CITY OF ALBUQUERQUE

**RE: T&M Self Storage
2301 Vista Oriente St. NW
Temporary C.O. - Approved
Engineer's Certification Date: 8/5/21
Engineer's Stamp Date: 2/12/19
Hydrology File: H10D032**

C2

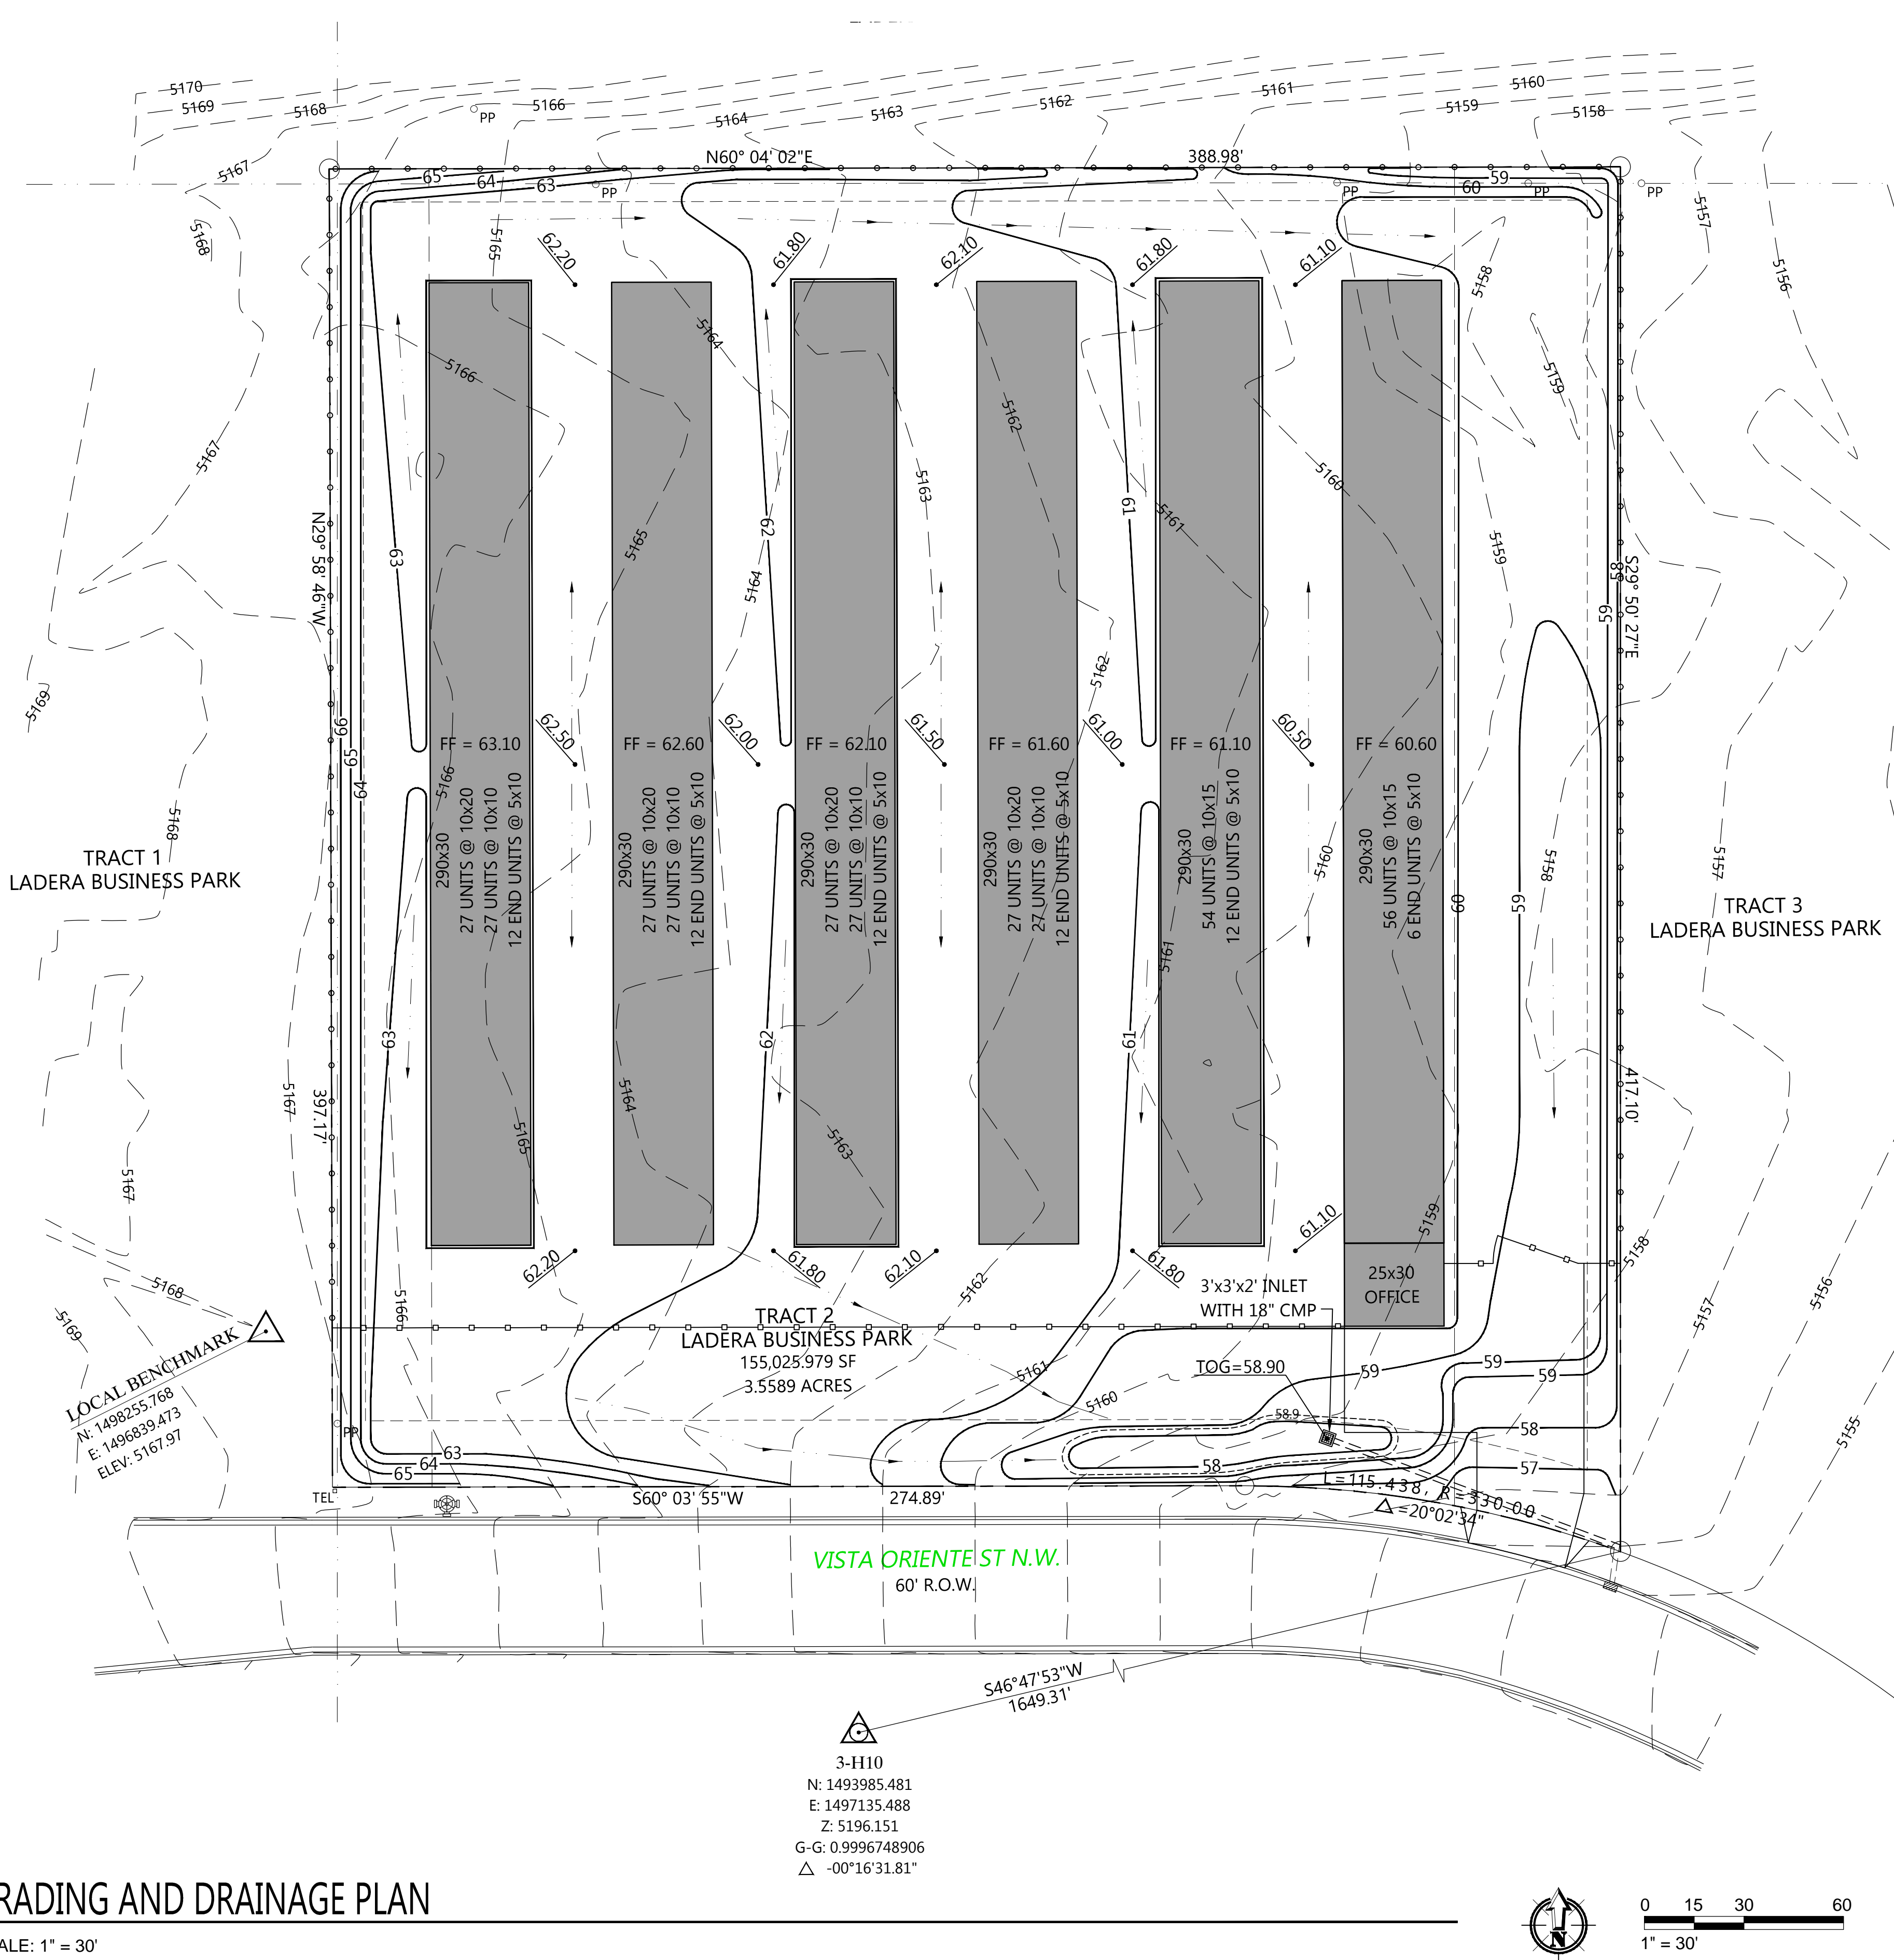
1. The drainage pond and channel needs to be constructed per the approved Grading and Drainage plan.
2. The pond needs to be stabilized with rock as it is highly erodible in its current condition. Please coordinate with James Doug Hughes with Stormwater Quality on erosion controls and permitting at 924-3420 or at jhughes@cabq.gov.
